Engineers Comments Regarding Surface Water Drainage

Application Reference:	LU/266/25/DOC	Reviewer Reference:	ADC/EXT5/AF
Planning Officer:	Kathryn Welch	Date of Review:	15/01/2025
Site Name:	Ambulance Station East Street Littlehampton BN17 6AU		
Application Description:	Approval of details reserved by condition imposed under LU/45/24/PL relating to condition 18-surface water drainage.		
Assessment Number:	1

- DRAINAGE LAYOUT AND DETAILS 25196/01 REVP1
- PLAN
- INFILTRATION TEST SPEC
- INFILTRATION TEST SPEC
- DRAIANGE REPORT

Drainage Layout - Attenuated Discharge
Scale 1:100 @ A1

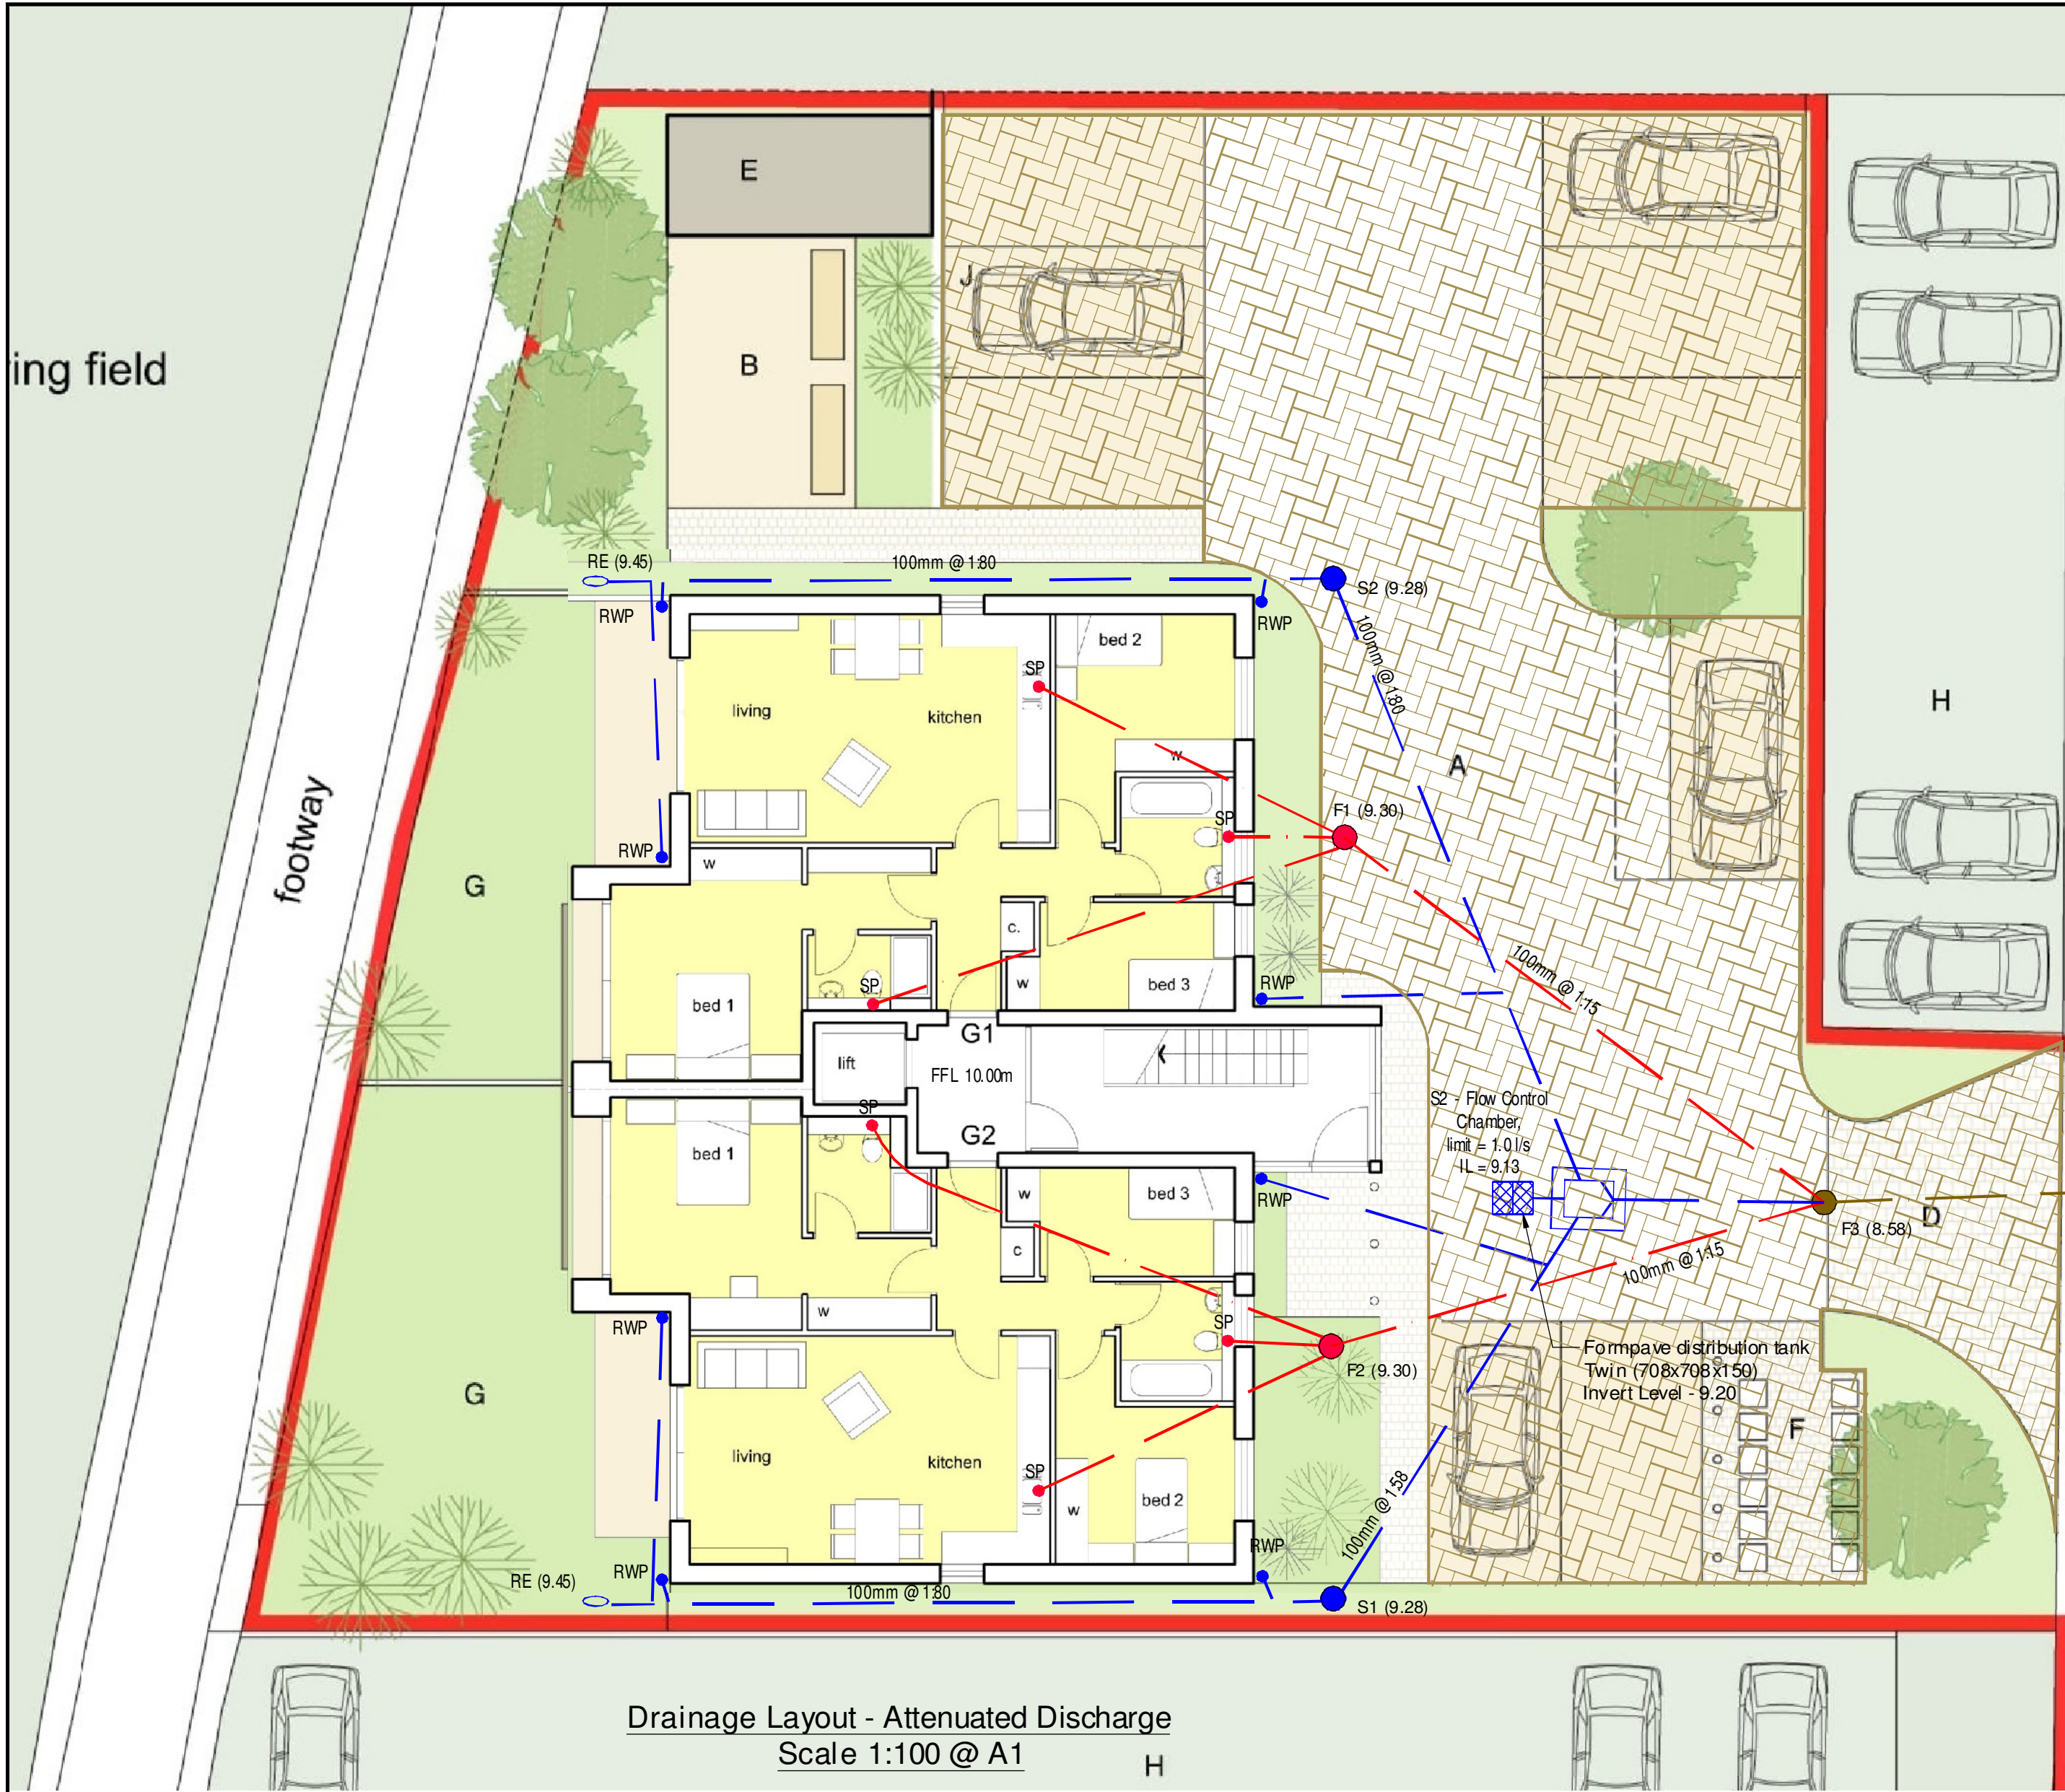
ADC Drainage Comments	Designer Response			
Date:	15/01/2025				
Condition Number: 18					
Comment Number					
1.	Confirmation of approval to connect to the combined sewer is required.				
2.	A full technical design should be provided to discharge conditions please provide levels design and details for pavements.				
3.	The proposed peak flow noted on the drainage plan has increased from the planning stage submission from 0.6l/s to 1.0l/s. Design peak flow should be based upon the per hectare GFR rates converted to a litre per second rate based upon the drained impermeable area.				
4.	The drainage calculations are based upon the Flood Studies Report and do not use the most up to date FEH rainfall data.

5.	The proposed flow control device has a small orifice and could be susceptible to blockage as there are currently upstream inputs not filtered through the permeable paving. The mesh grill is noted and we would also wish to see a high level overflow to prevent flooding in the event of blockage. Consideration should also be given to filtering rainwater from roof areas prior to discharge.

6.	The rain gardens and filter drains included at planning stage are removed and should be reinstated or design changes justified. The roof drainage could also potentially be filtered through the permeable pavement foundation.

7.	The drainage plan should confirm the base level and any base gradients within the porous attenuation foundation.				
8.	The technical design should be supported by drainage calculations which analyse the system as a network including pipes, attenuation, flow control and outlet.

9.	Water butts shown at planning stage are missing from the design.
